From: Ian Stocks [REDACTED] **On Behalf Of** FRS Water and Access
Sent: 31 May 2022 14:03
To: Planning.Responses <Planning.Responses@arun.gov.uk>
Subject: Planning consultation - BR/48/22/PL 13-17 Richmond Avenue Bognor Regis, PO21 2YE

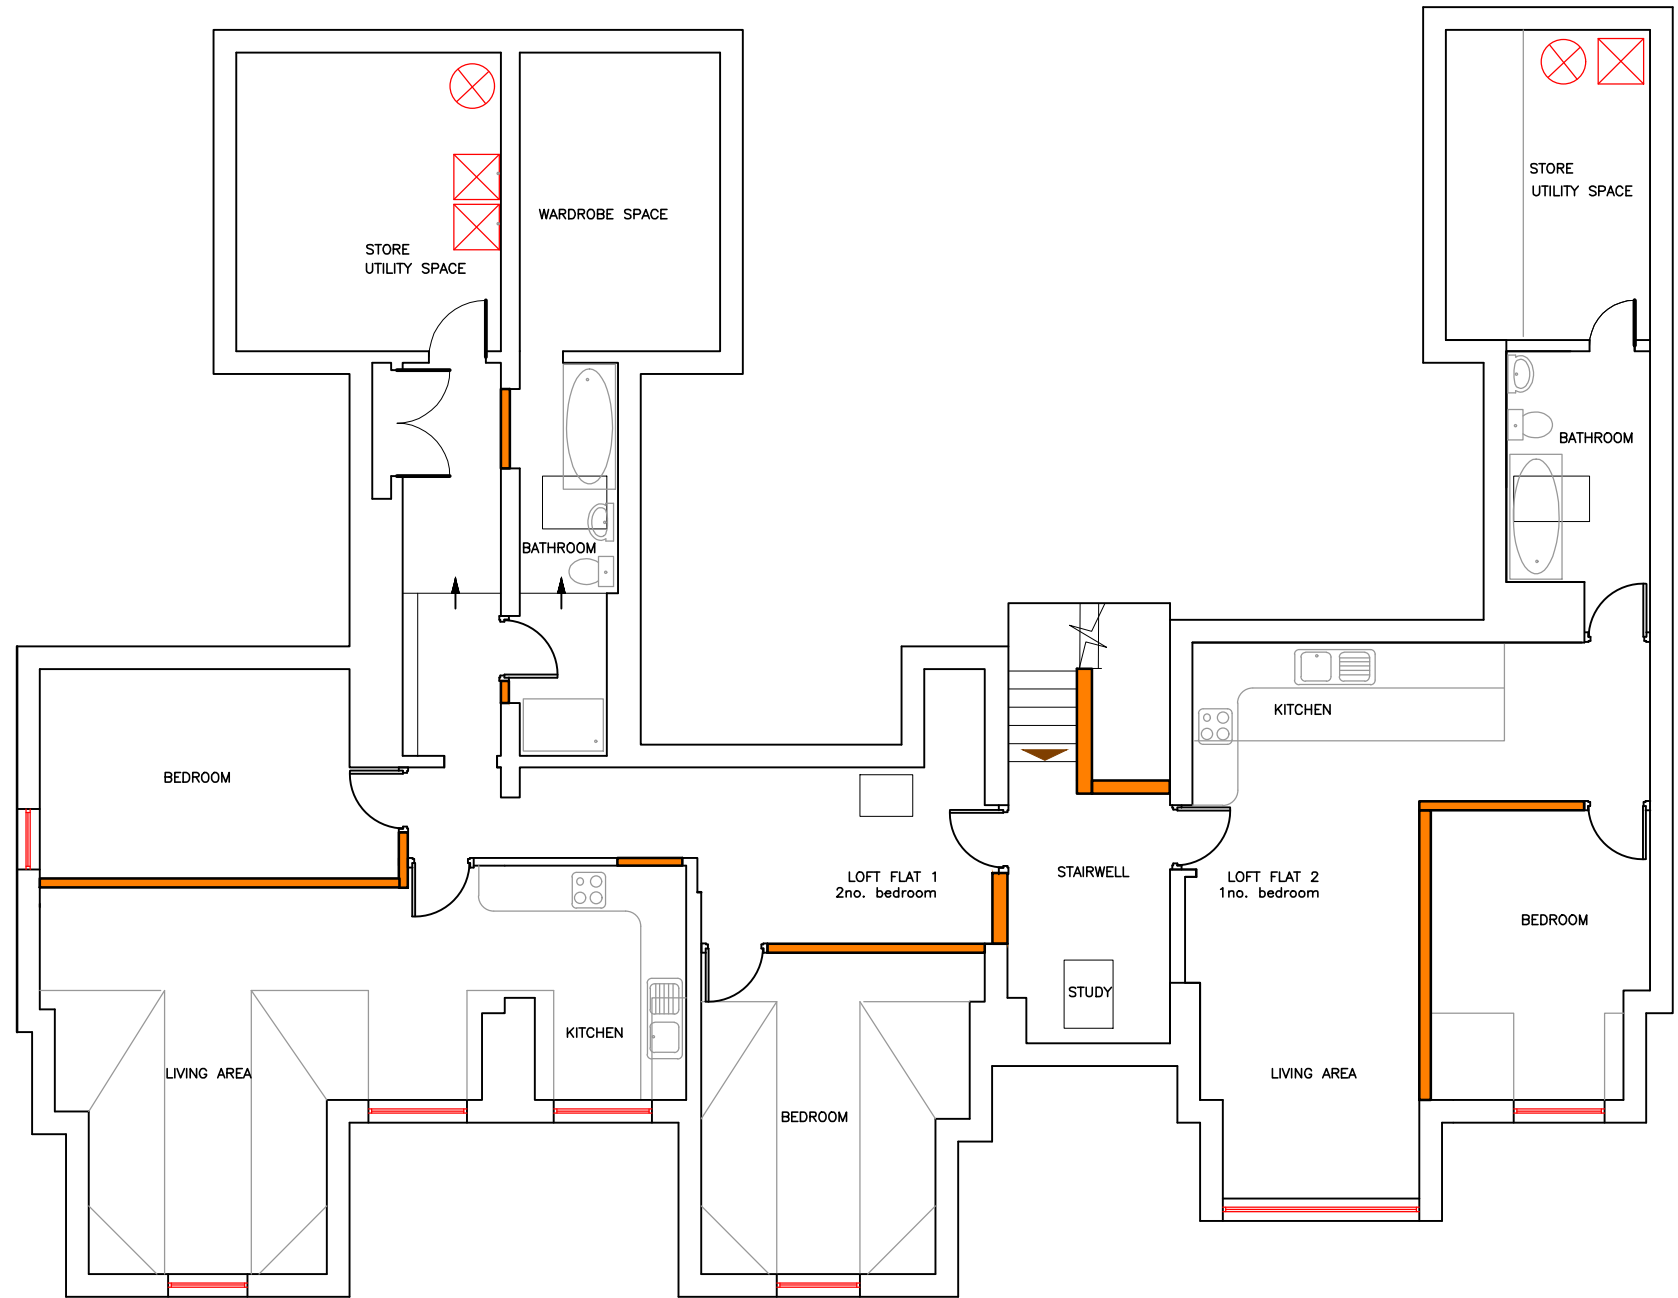
Having viewed the plans for the planning application no. BR/48/22/PL for Conversion of existing loft space into 2 No. flats. This application is in CIL Zone 4 (Zero rated) as flats, evidence is required to show that all parts inside all flats are within 45 metres of a fire appliance in accordance with Approved Document B Volume 1 2019 Edition B5 section 13. This is to be measured along the hose lay route, not in a direct line or arc measurement. Any areas not within the 45 metre distance will need to be mitigated by the installation of domestic sprinkler or water mist system complying with BS9251 or BS8458 standard.
